## Jeanie Bourke - Re: FW: greenhouse

**From:** Jeanie Bourke  
**To:** JDriscol@megalink.net  
**Date:** 1/28/2015 3:45 PM  
**Subject:** Re: FW: greenhouse

**From:** fredr@parisfarmersunion.net [mailto:fredr@parisfarmersunion.net]  
**Sent:** Tuesday, January 27, 2015 12:58 PM  
**To:** Sue Driscoll; JDriscol@megalink. net  
**Subject:** greenhouse

SUN LITE  
 ASSEMBLY & DETAILS

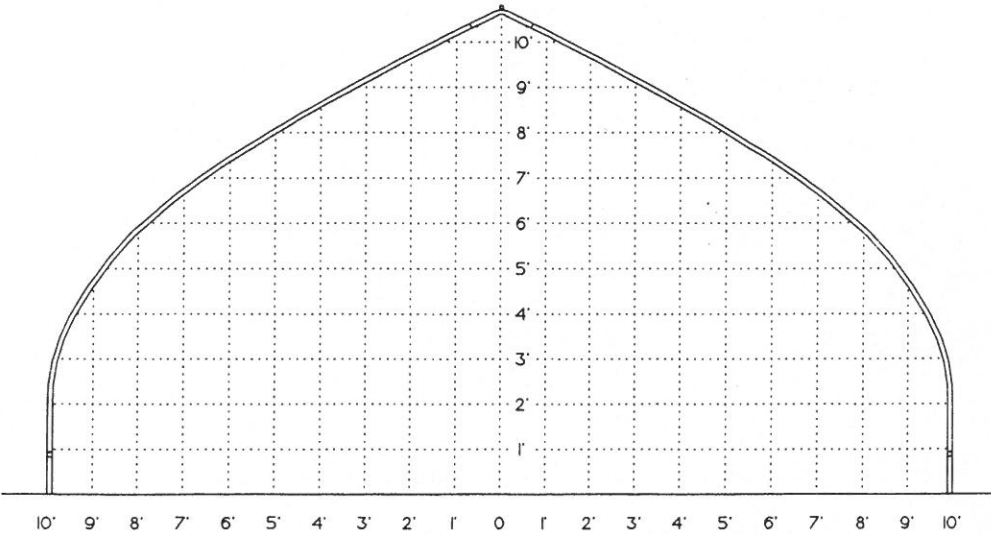
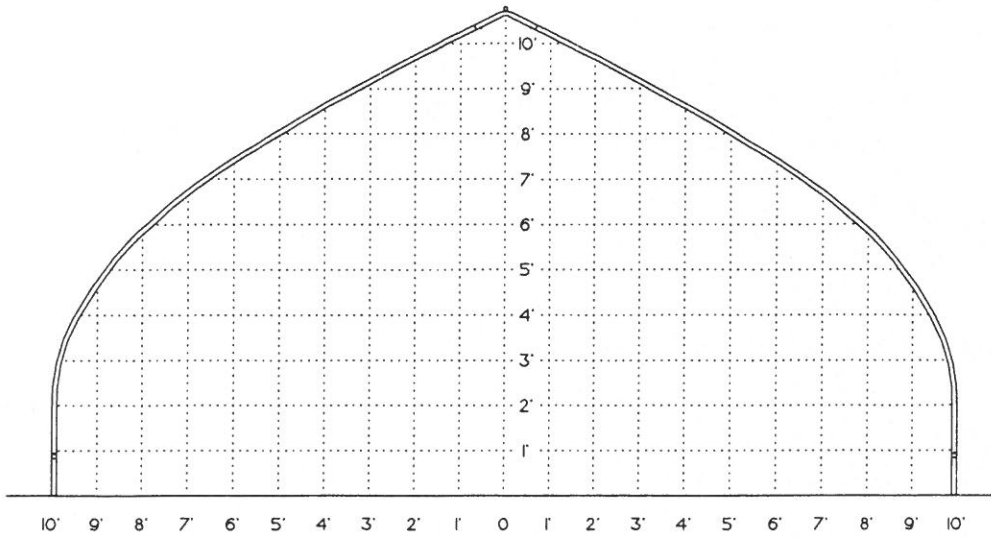
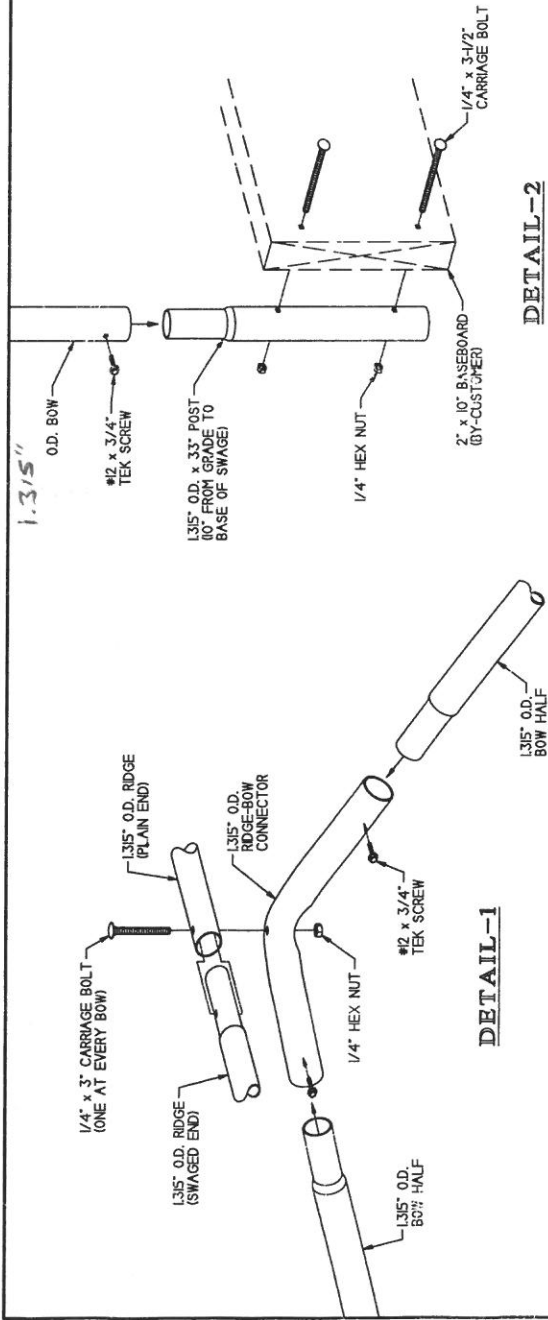
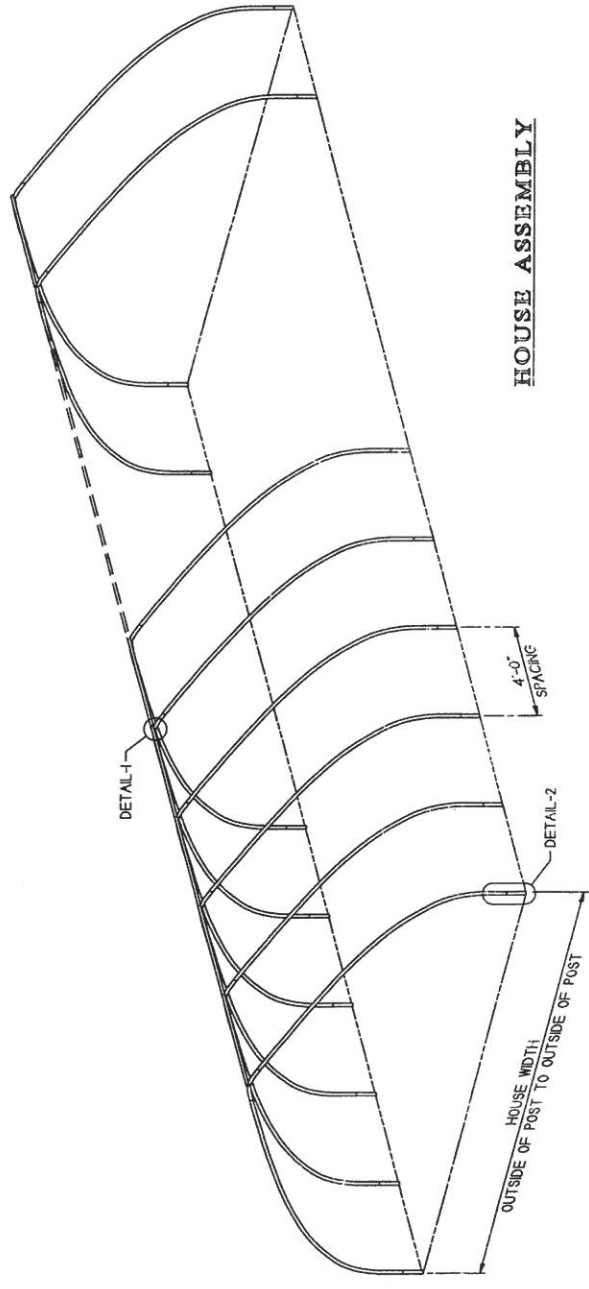
1. The code does not require frost protection for Category I buildings, however, anchorage is required to resist uplift and sliding forces. A 2x10 baseboard is specified to be installed by the customer, please verify this detail and wood type. (4" x 4" plate connected to the arch with 4 - 3/8" holes to be lagged to a 2"X10" PT which is anchored with 1/2" X 24" rebar to the asphalt). Also, provide details on the base of support, ie. prepared soils, asphalt, etc. (asphalt)

2. Greenhouse buildings are required to be designed and constructed to sustain dead loads, tension loads and live loads including wind and snow. Please provide any additional details and manufacture specifications for the design parameters of this structure.(The New England Gothic style structure from Rough Bros. can be engineered with certified stamped drawings, however Griffin would need to know the snow and wind load requirements from your local zoning. After zoning tells us what is needed, we can then go back to engineering and see if it is possible. The structures as they are carry no certification.)

3. Please provide details of the membrane, thickness and attachment details. (please see attachments) Is the greenhouse for storage only or will there be occupancy by the general public? (storage only)
